Submission Form

Epping to Thornleigh Third Track Proposal. Application number SSI 5132.

I/we object to the Epping to Thornleigh Third Track Proposal and consider that the EIS is inadequate and does not address the full impact of this proposal. It will cause untold damage to the health of residents and to the fabric of the Beecroft Cheltenham Heritage Conservation Area. Do not approve this project, reconsider the alternatives and protect the community.

Figure 5.6 Cross-section and elevation - New Cheltenham Station concourse building
Note: Indicatively added to future design

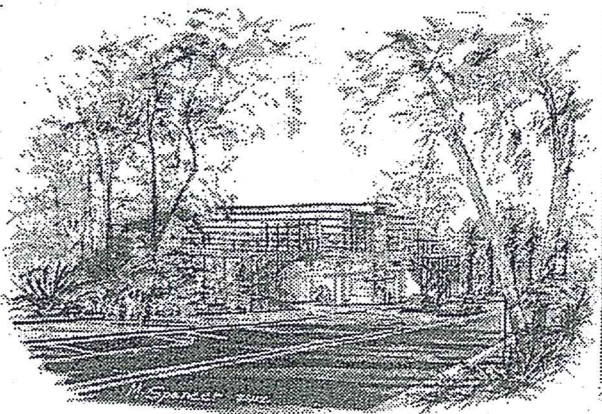
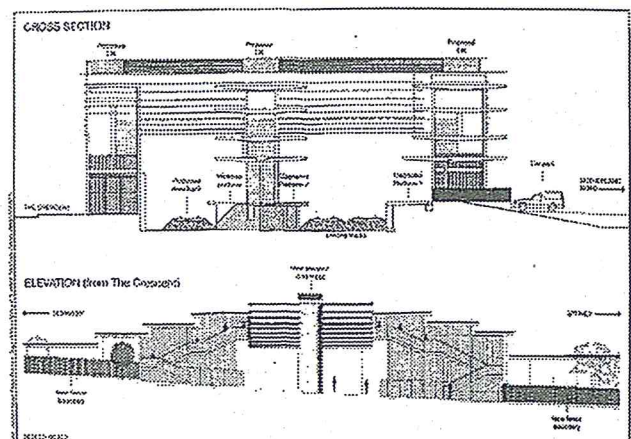
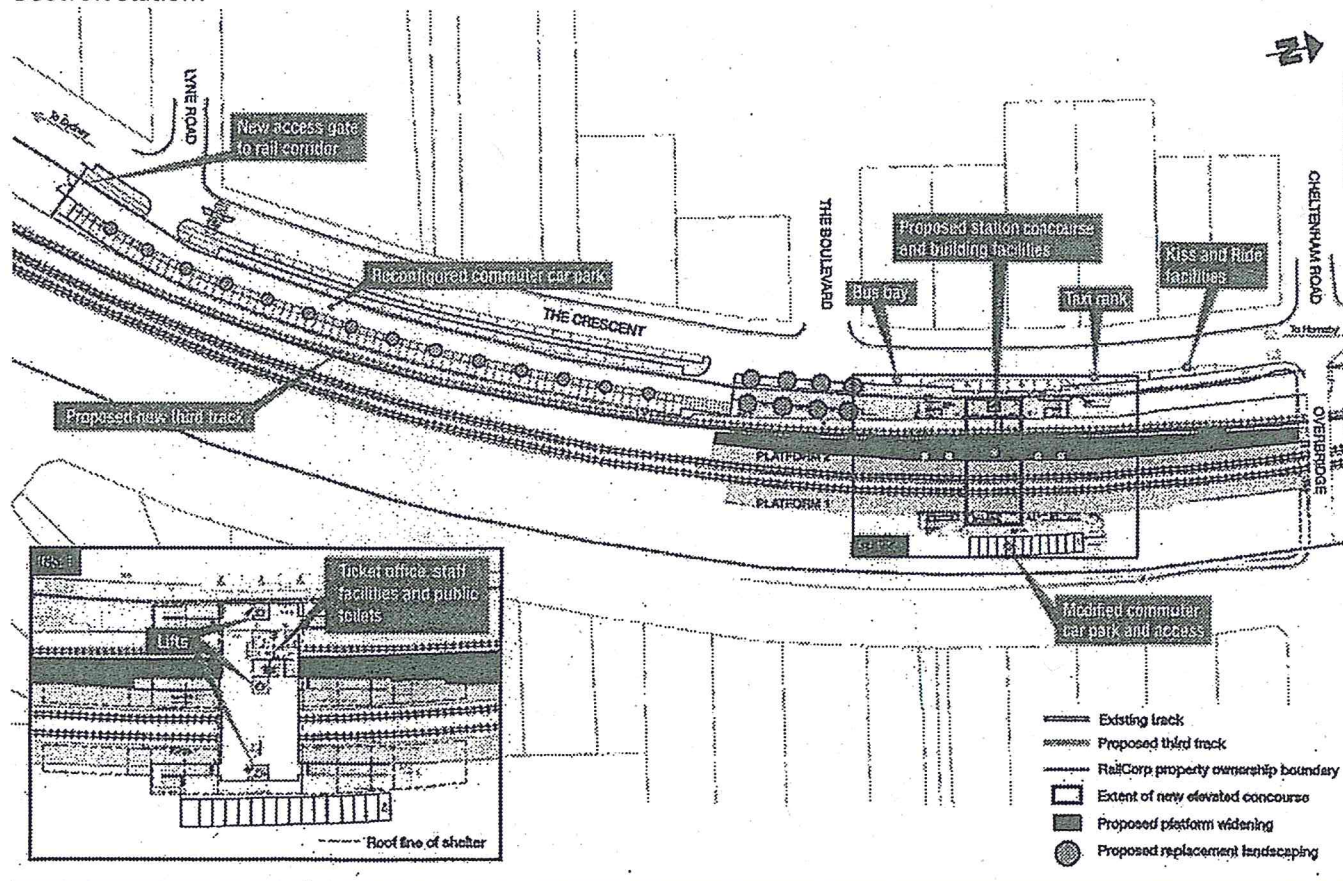
- The proposed redevelopment of Cheltenham Station shows no regard for the HCA. The visual impact of the proposed 13m high glass and steel concourse is totally unacceptable in this HCA.
